DECISION DELEGATED TO HEAD OF PLANNING

Application No: H07-0594-23 **Applicant:** Mr A Zdroba

Proposal: Details of first floor window, additional tree planting and surface water disposal (Conditions 3, 4 and 6 of H07-0987-22)

Location: 32 Hillgate Gedney Hill Spalding

Rev C 28/07/23 Olive tree noted
Rev B 22/11/20 Plot dims added
Rev A 08/11/20 Landscaping added
Project: New House
Client: Rebecca Zdroba
Address: 32 Hillgate Gedney Hill Spalding PE12 0NN
Drawing Title: Site Plan
Drq No: 03
Scale: 1:200 @ A3
Date: Nov 2020

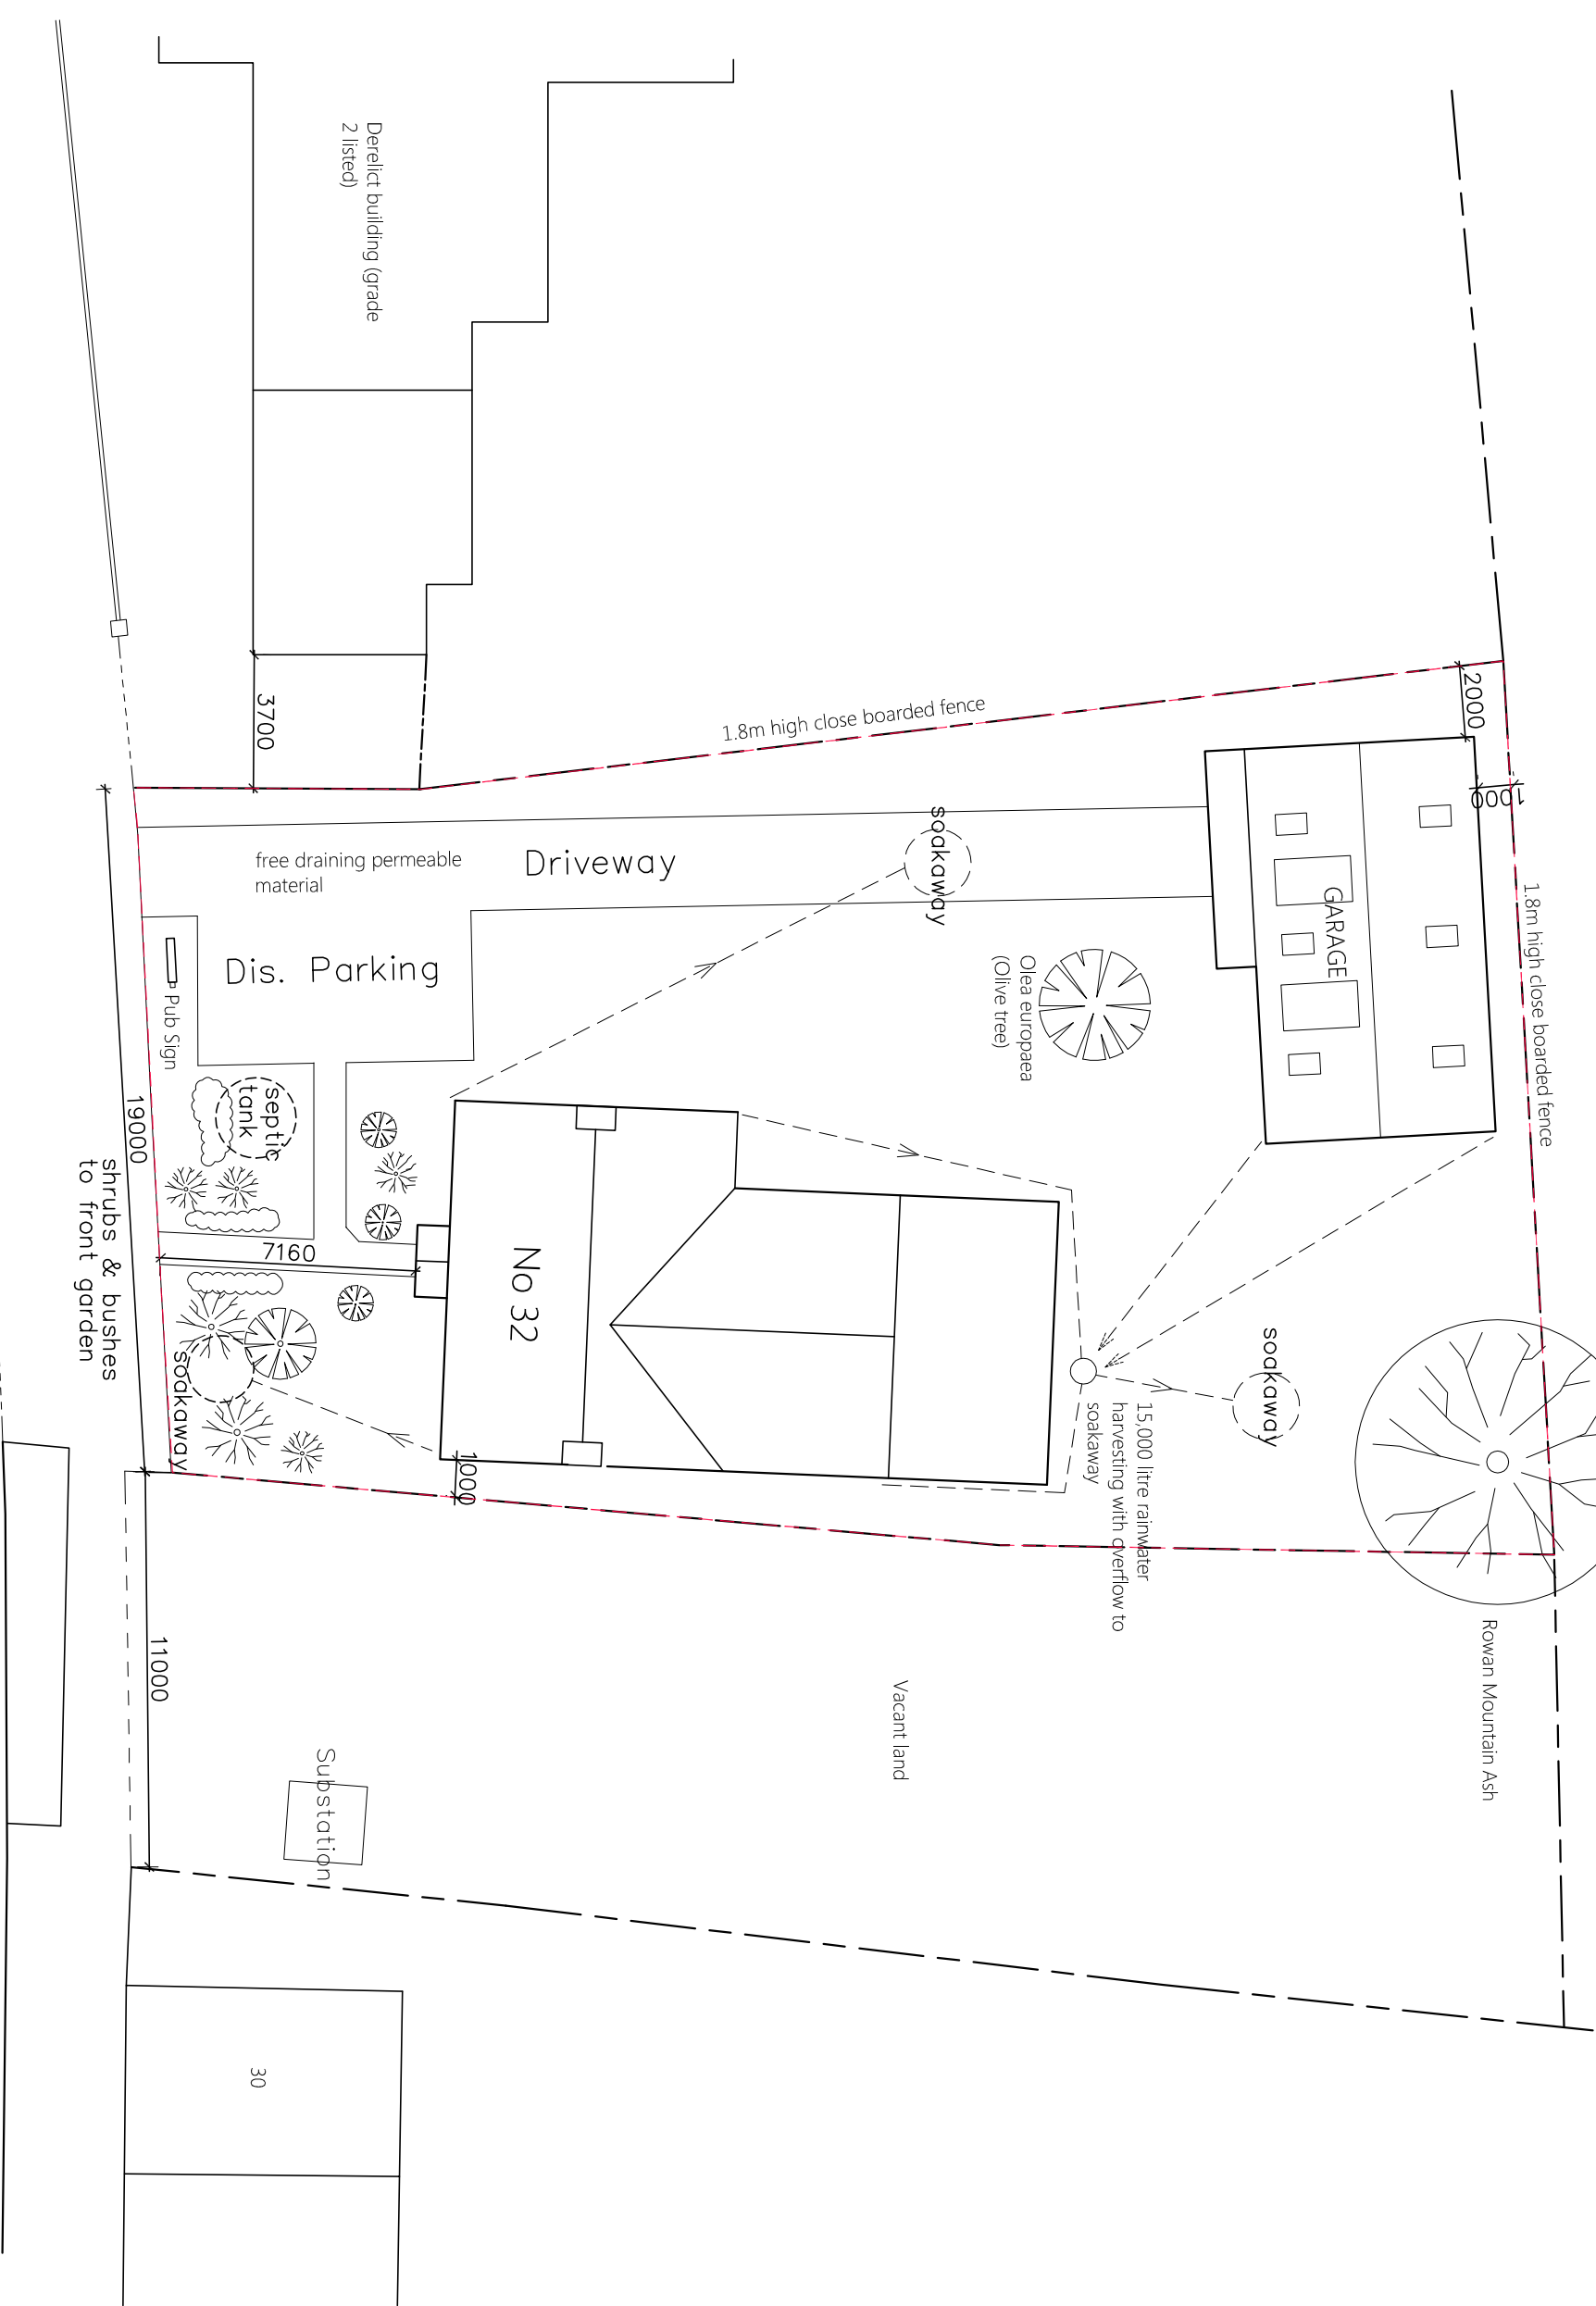
Condition 4 (additional tree planting) - Planting upon the site includes a Rowan (mountain ash) and an Olive tree, plus shrub planting within the front garden. The details are considered acceptable on balance.

| Drq No: 03        |                       |

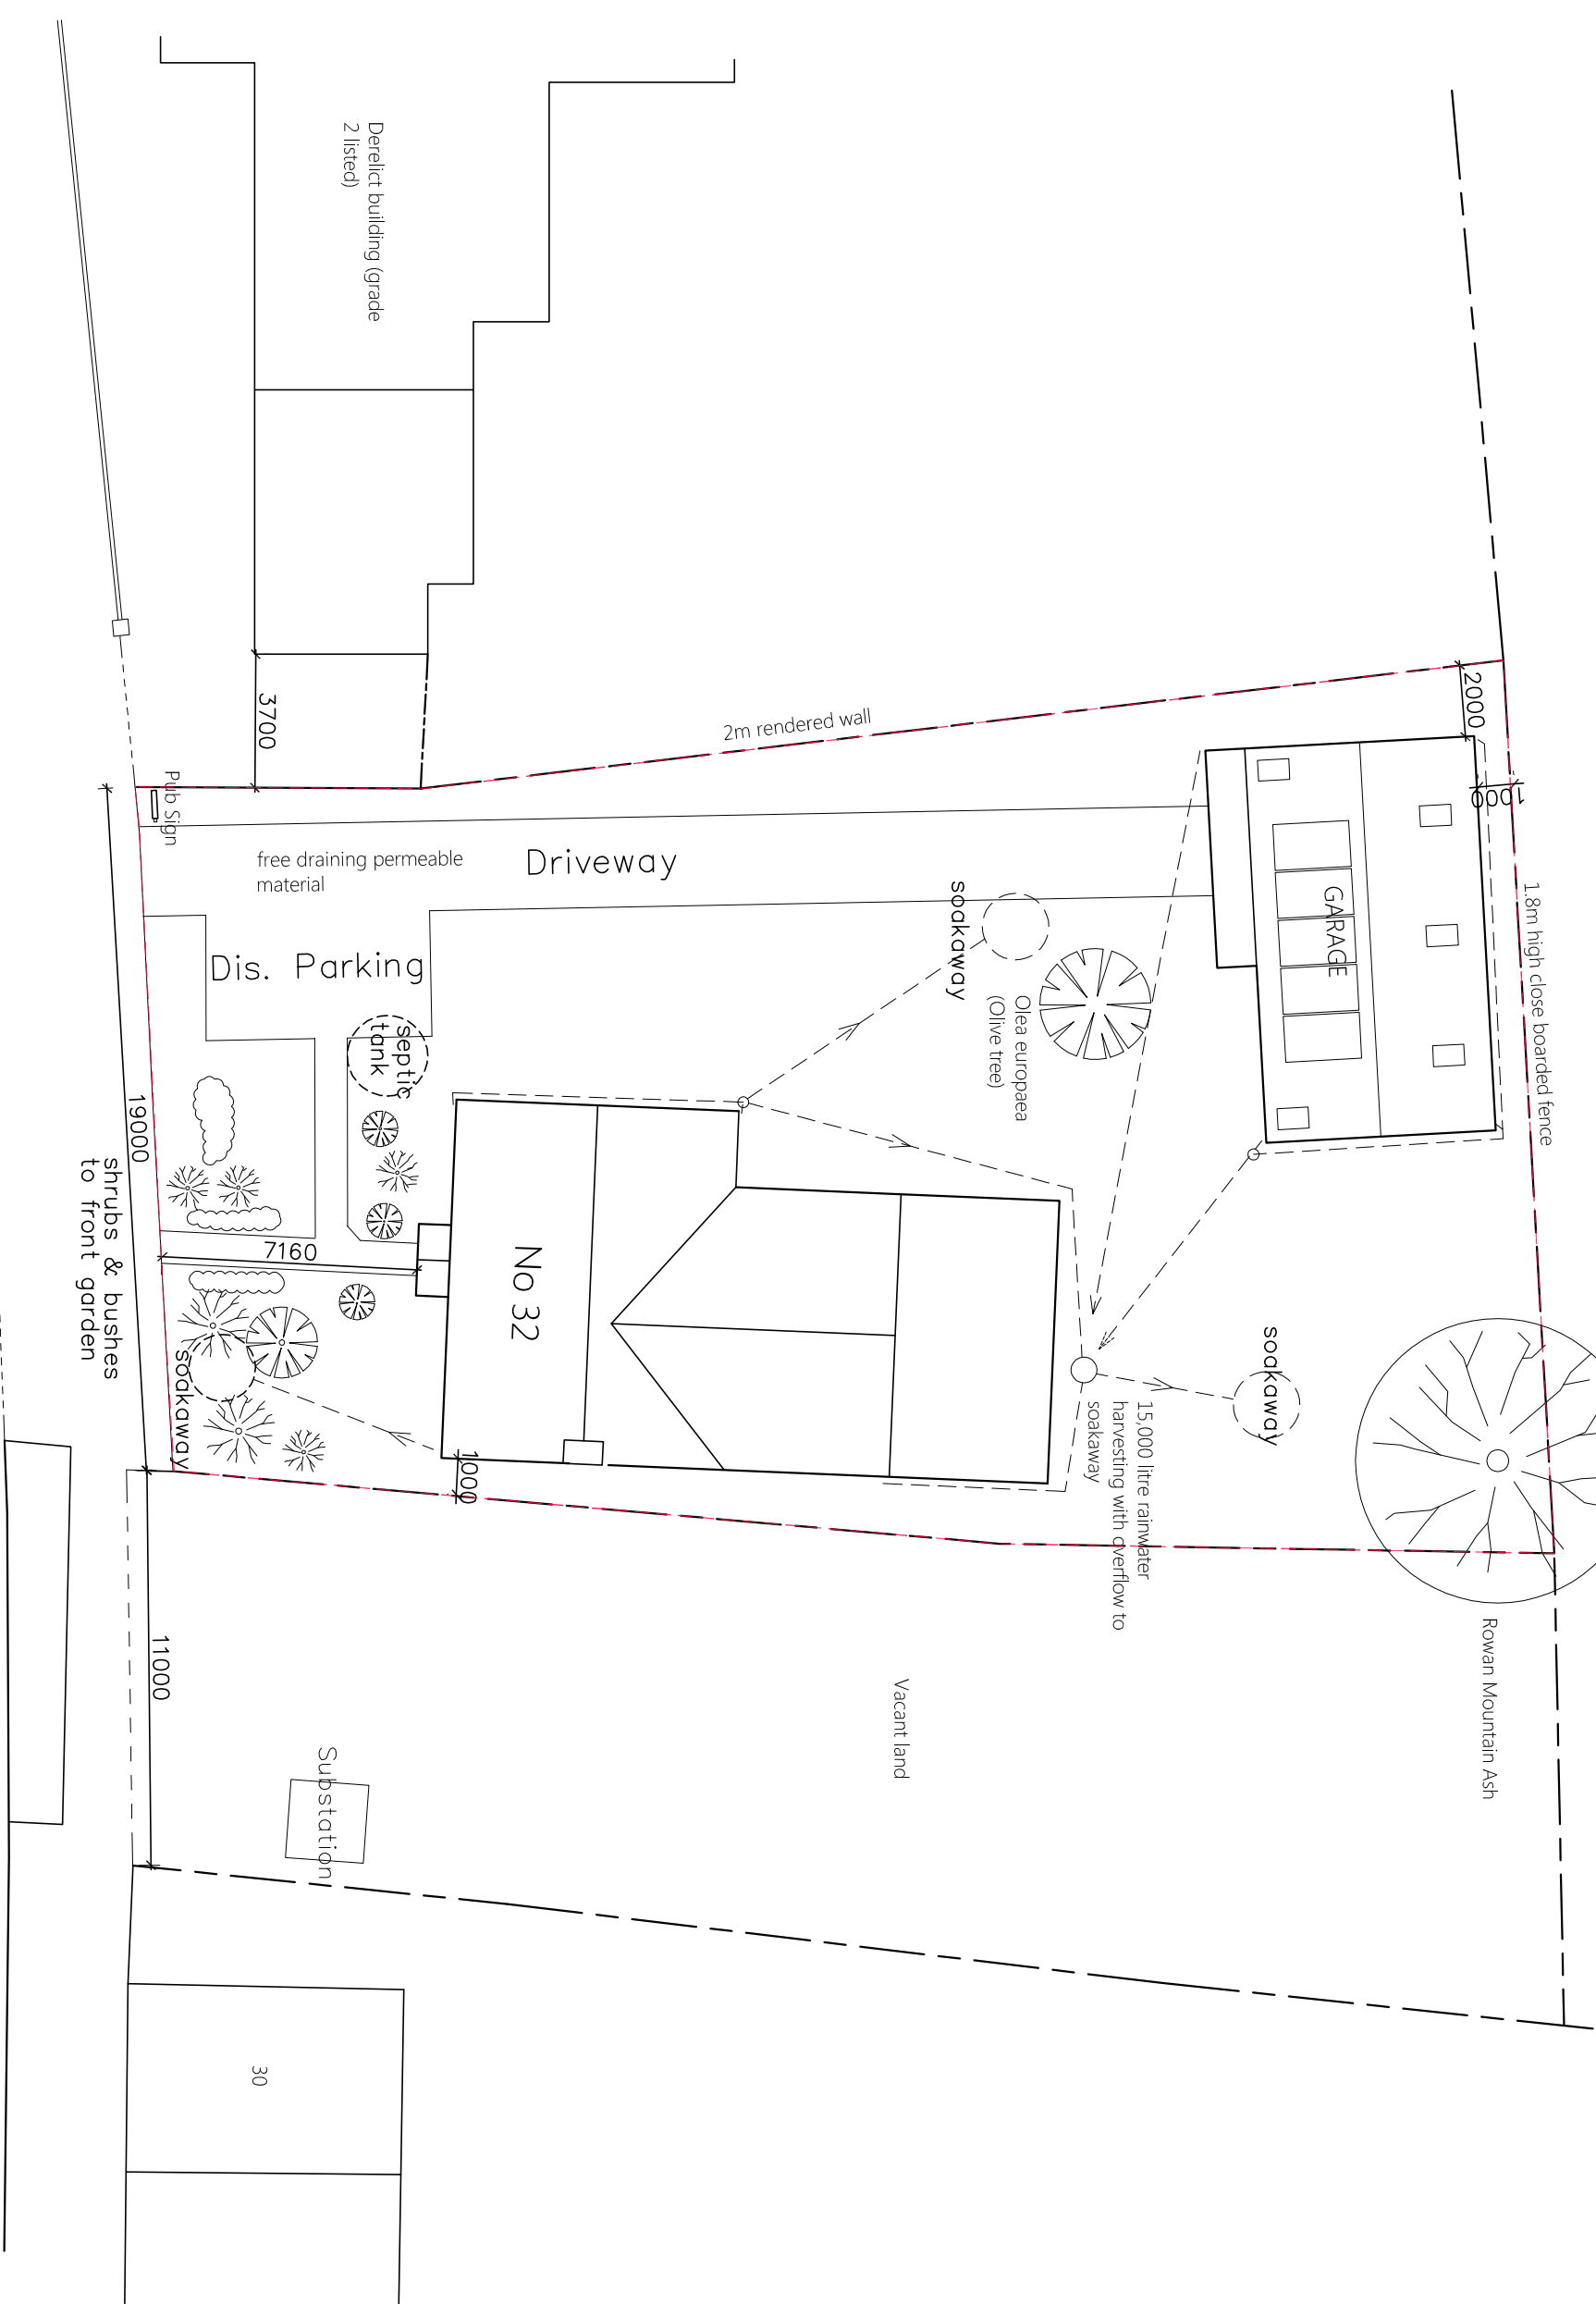
Note that this is a part retrospective application and that the applicant is disposing of surface water via infiltration by using a rainwater harvesting system with an overflow to a soakaway. We would typically recommend that the proposed strategy is supported by infiltration testing in line with BRE Digest 365 (or equivalent) to see whether the soakaways can work efficiently. If the soakaways have already been installed, we would ask that you as the LPA should satisfy yourselves that this system is viable in this location without increasing flood risk on or adjacent to the site.

Condition 6 (full details of means of surface water disposal) - The applicant proposes disposing of surface water via infiltration by using a rainwater harvesting system with an overflow to a soakaway. The South Holland Internal Drainage Board has recommend that the proposed strategy is supported by infiltration testing in line with BRE Digest 365 (or equivalent) to see whether the soakaways can work efficiently. This is especially bearing in mind the clay soil within the Gedney Hill area. However, no percolation test results have been submitted. Consequently, it has not been demonstrated that the proposed surface water drainage strategy is satisfactory.
